**Jindera Solar Farm (SSD-9549)  
Request for Additional Information**

I refer to Assessment for the Jindera Solar Farm. After careful consideration, the Department is requesting that you provide additional information.

Haulage Route - Map 1

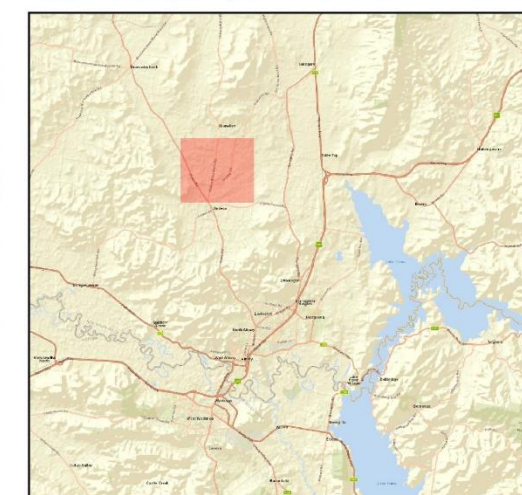
- further clarification on the use of Ortlipp Road and the emergency site access point, including traffic associated with the construction and operation of the transmission line, substation and battery energy storage;
- confirm the haulage route from the State road network (Hume Highway) and provide a figure which identifies this route; and
- confirm the number of over-dimensional and heavy vehicle movements per day during both construction and operation of the development.
